From: Laura Gibbons
Sent: 07 November 2018 13:28
To: Planning.Responses
Cc: Michael Eastham
Subject: RE: Planning Consultation on A/82/18/DOC

Engineers Comments Regarding Condition 6

A/82/18/DOC

Quiet Waters Roundstone Lane Angmering BN16 4AX

TYPICAL PRECAST SOAKAWAY
ARRANGEMENT
1:25 @ A3

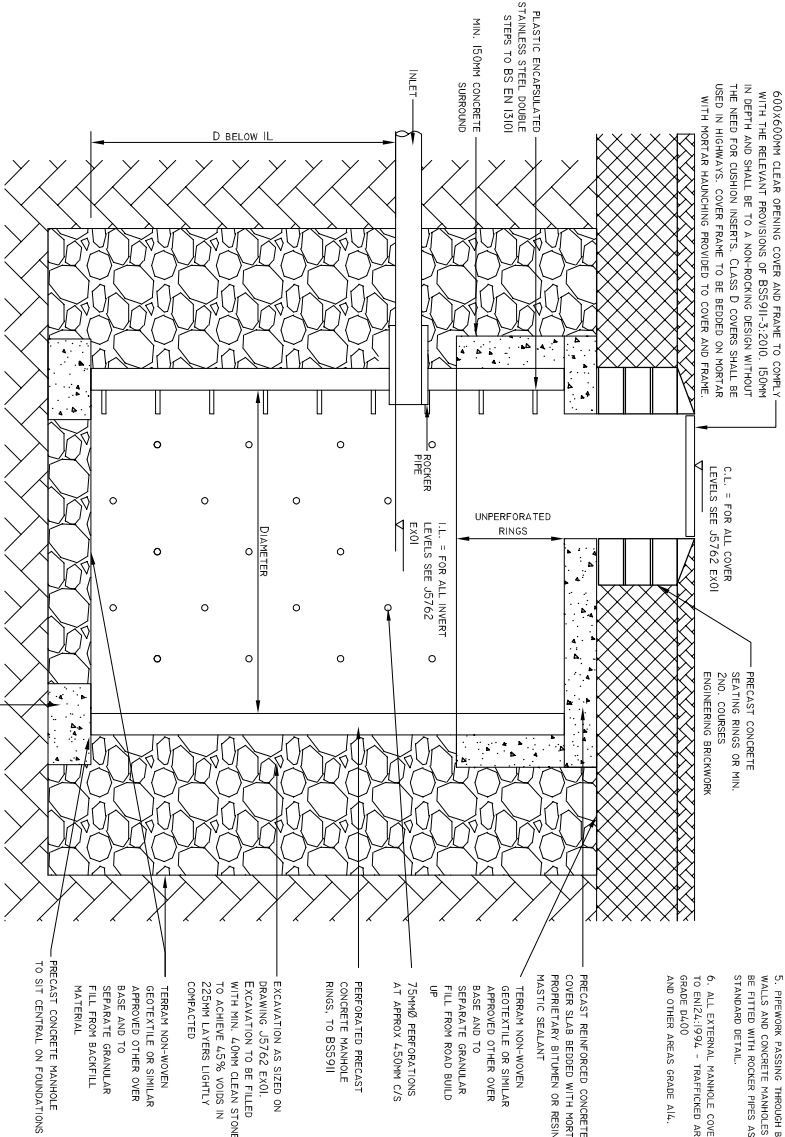
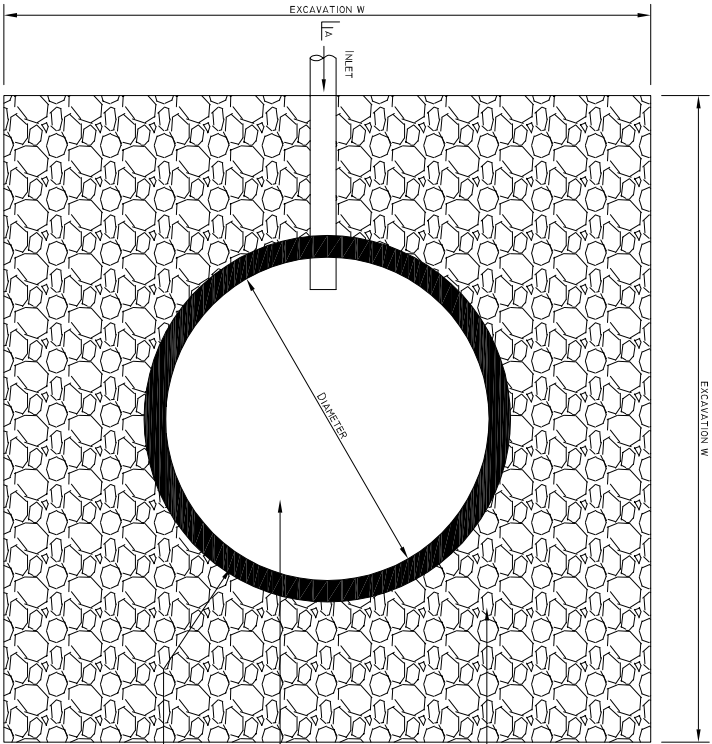
- Please provide justification for the infiltration rate used (6.48 m/hr) for the eastern soakaway.
- What treatment is being provided for the surface water from the road?
- Can construction detail drawings please be provided.
